RE: 2025/91638 - The Mansion House, Heaton Lodge, Bog Green Lane, Colne Bridge, Huddersfield, HD5 0RF

Our attention has been drawn to the above planning application (for residential development) that has been submitted on land very close to the works associated with the Trans-Pennine upgrade in the Bradley area.

Site plan (1:500)

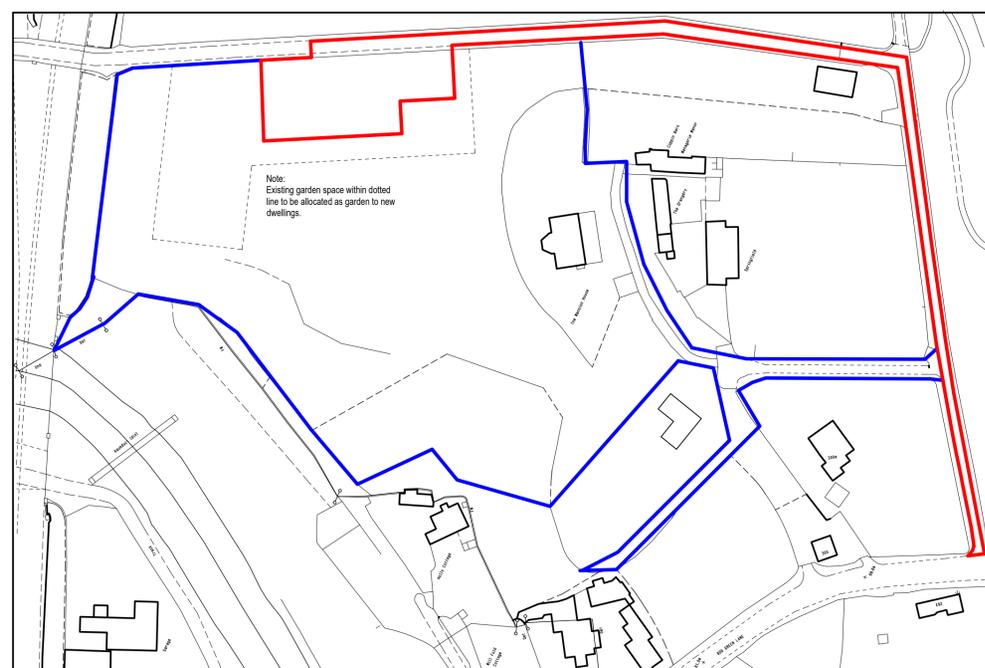
We would first point out that the ownership certificate on the planning application is incorrect; part of the land contained within the red line boundary has been vested to Network Rail following the grant of the Transport & Works (Huddersfield to Westtown) Order and is not in the control of the applicant. The plan attached (0733499-1A) shows the land ownership of NR (in red) superimposed over the application site.

Secondly the reason for the acquisition of that land was to facilitate the re-orientation of an 11kV overhead electricity line further away from the railway. The proposed position of the line is shown on the second drawing (WYK-340880). It will be 5m high and will include an air rights wayleave between 4-5m for maintenance purposes. As you will see this follows the land vested in NR and cuts right across the two proposed plots nearest the railway. Given the safety issues involved it is clear that the current residential layout is not feasible and we therefore object to the application in that it seeks to interfere with land specifically set aside for the purposes of re-orienting an electricity cable required as part of the upgrade of the railway.

We do not comment on the appropriateness of the development in its rural location save to say that, if permitted (assuming a new layout has been provided to take into account land ownership and the route of the revised 11kV cable) each dwelling should be the subject of a noise assessment and be adequately soundproofed accordingly given its close proximity to the working railway.
